**Re: Marist Catholic College North Shore (SSD-10473)
Response to Submissions 2**

We refer to the response provided by DPIE dated 20.12.21 to the State Significant Development Application for Marist Catholic Collage North Shore and specifically the comments on the landscape design and provide our response as follows.

- Tree to be retained (39)
- Tree to be removed (63)
- Tree to be transplanted (2)
- Proposed Tree
- Transplanted Tree

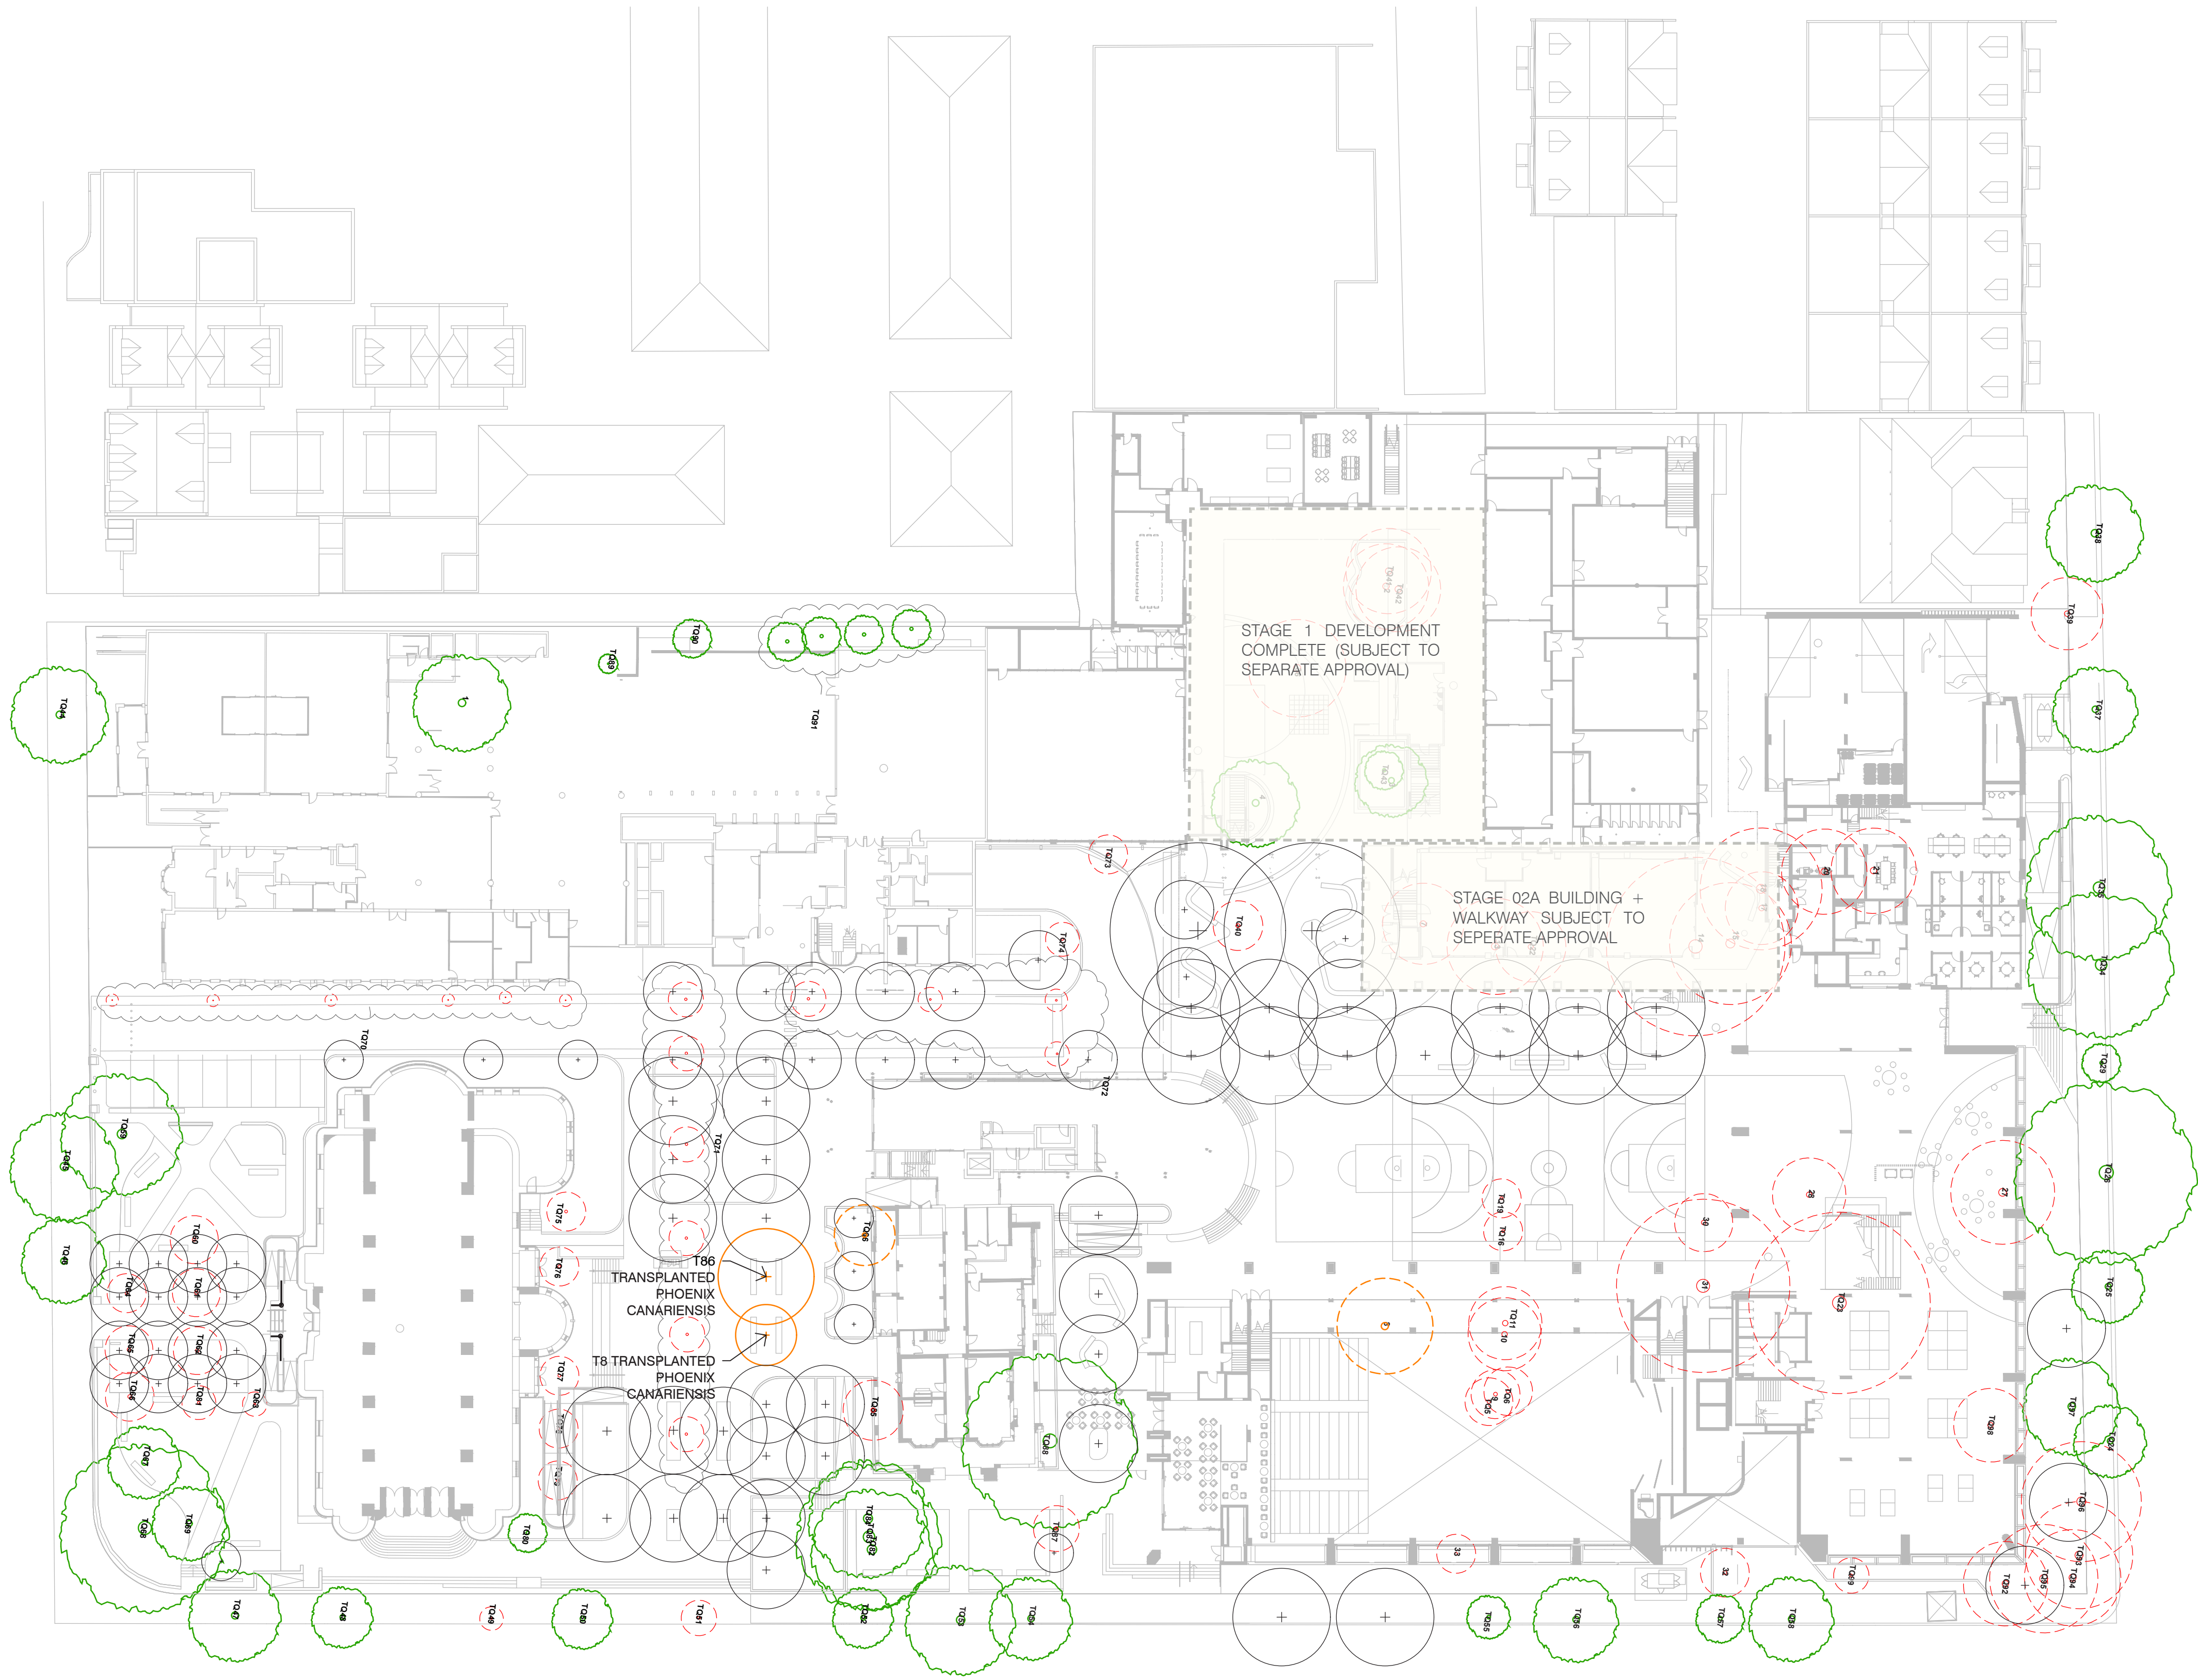
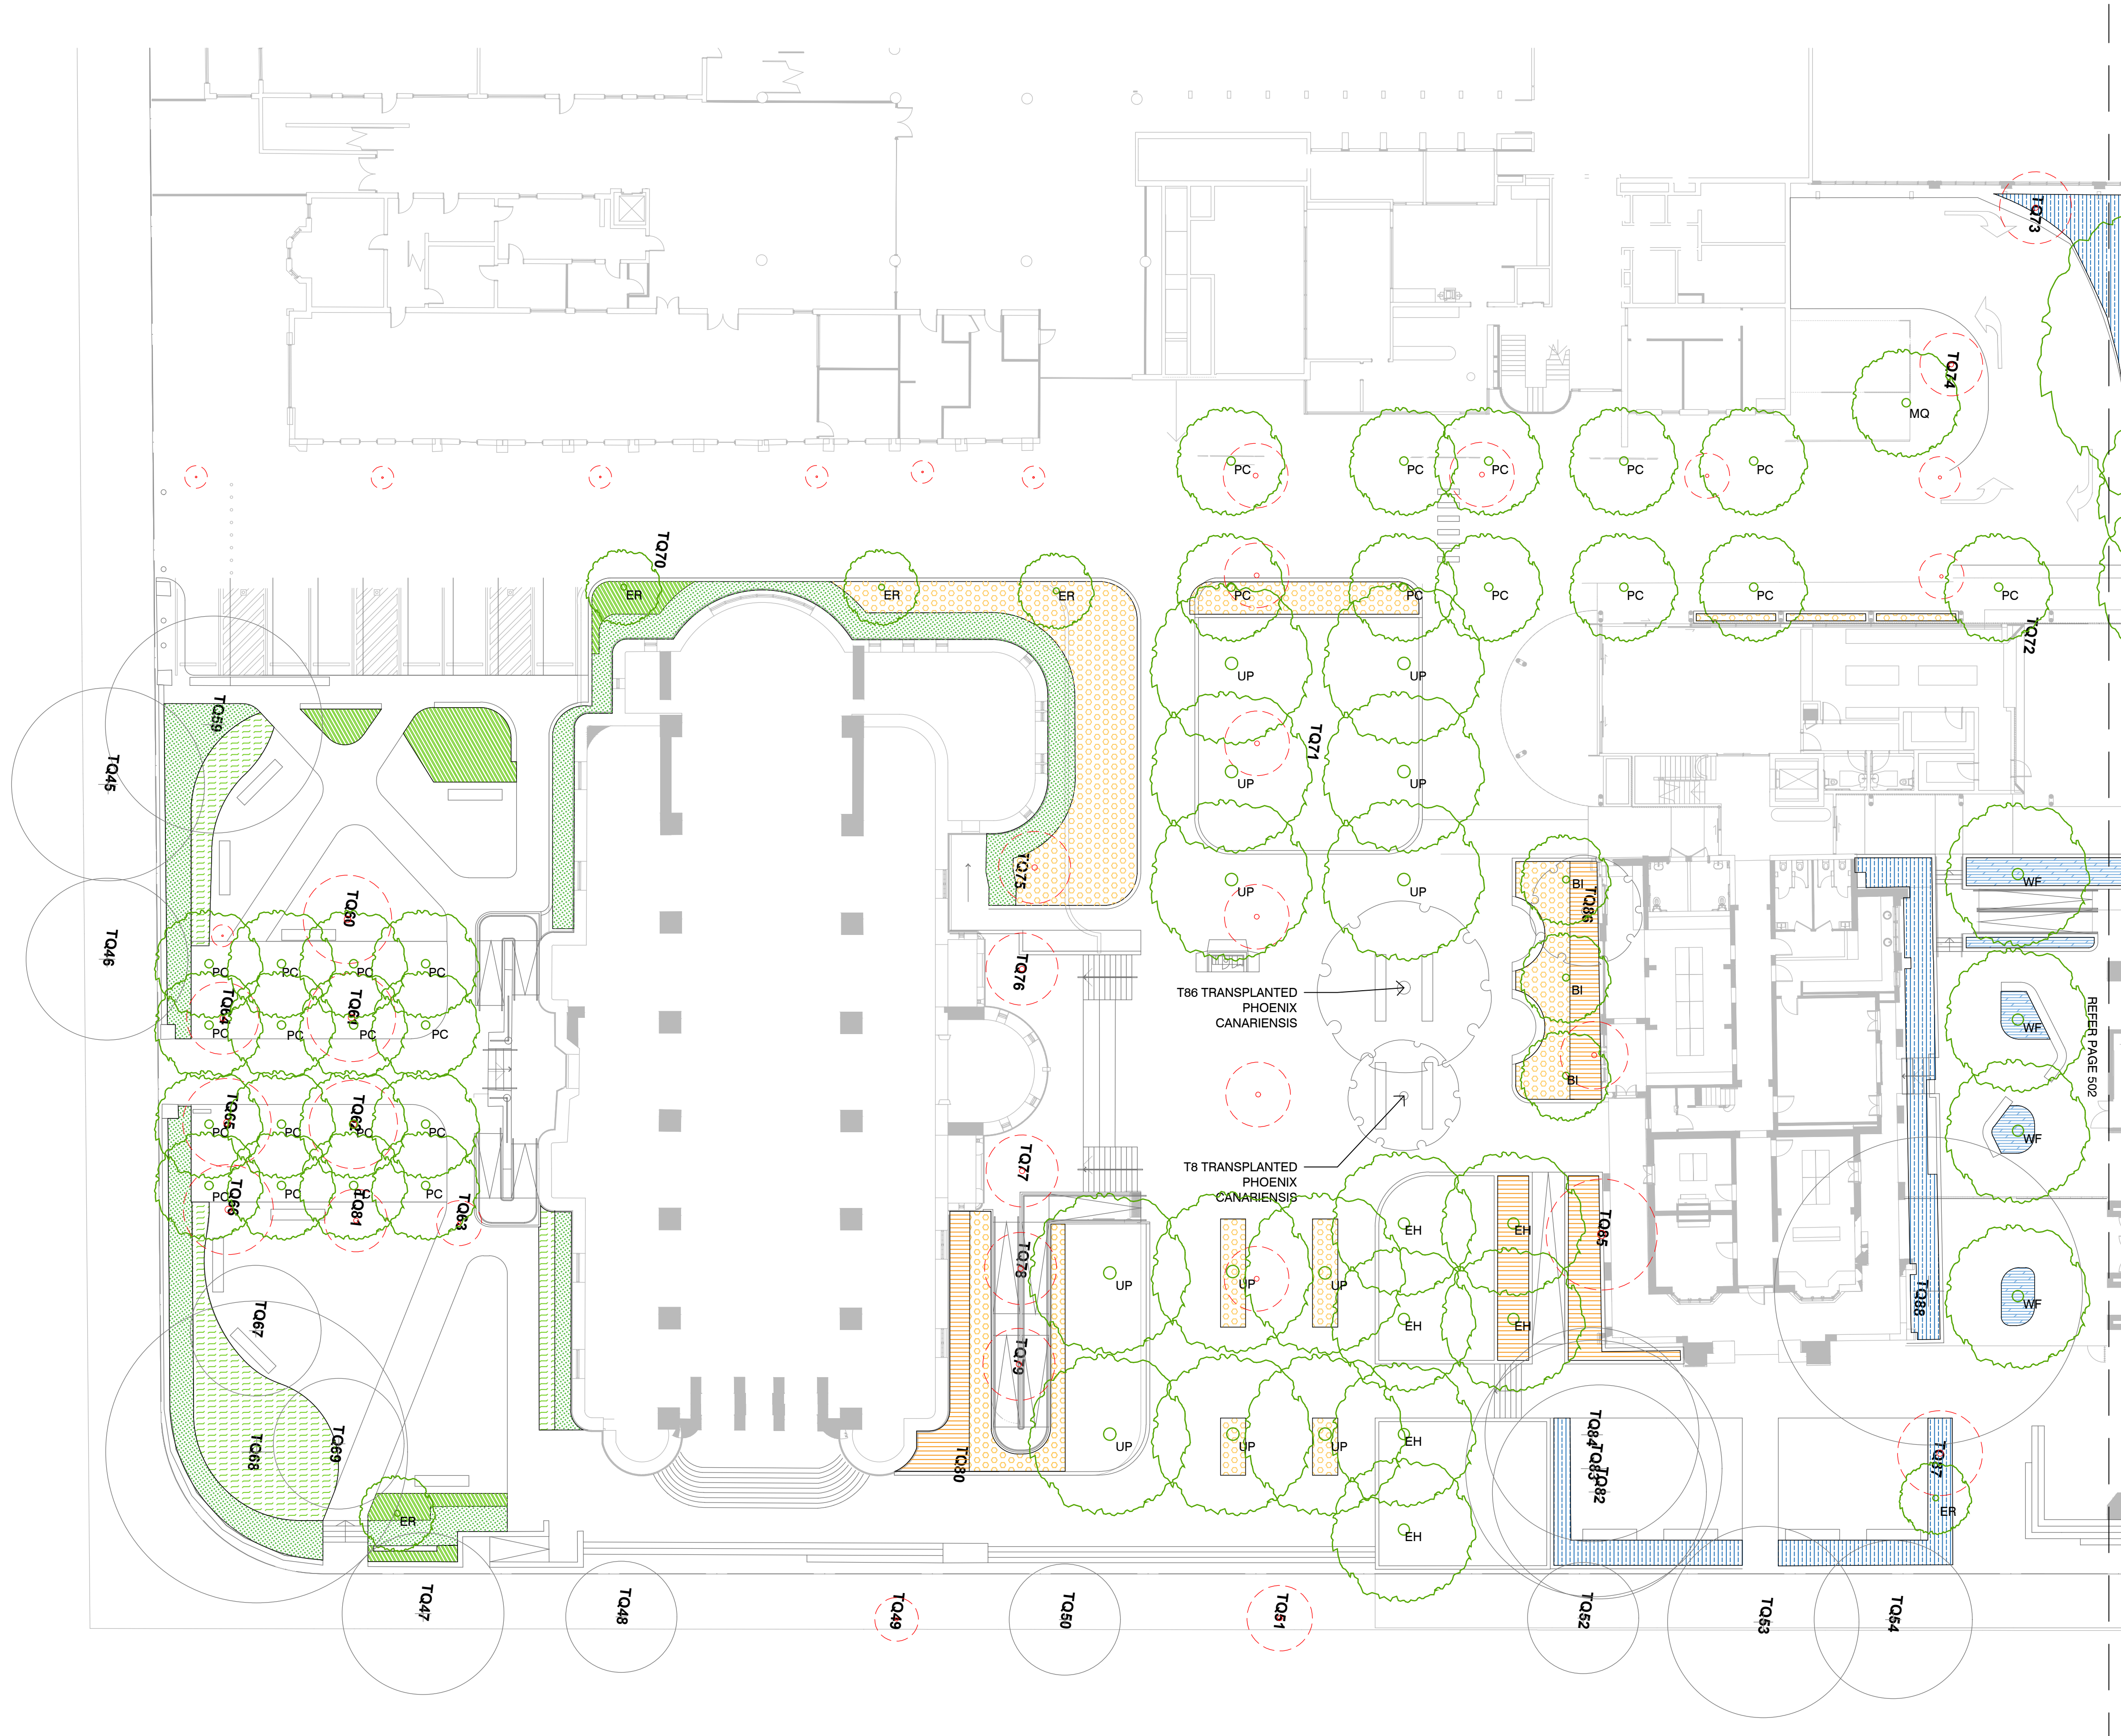
- clarify the total number of trees for removal and retention. In particular, clarify whether the two trees now proposed for retention (transplanting) are included within the calculation of total number of "trees for removal" (59) OR "trees for retention" (17).

- confirm the total number of proposed replacement trees, noting the RtS and Arboricultural Impact Assessment indicate 60 replacements, however, the updated landscape plans indicate 108 (70 at ground level and 38 at roof terrace levels).

Response: There are 44 trees proposed for retention (2 high value, 7 moderate value, 13 low value, 21 unspecified value and 1 un-surveyed).

There are 64 trees proposed for removal (3 high value, 7 moderate value, 47 low value, 2 unspecified value and 5 un-surveyed).

The 2 trees proposed to be transplanted (T8 & T86) are included within the total number of "trees for removal".

Response: There are 114 replacement trees proposed in the updated landscape plans. Refer to L-005 and L-007-009.
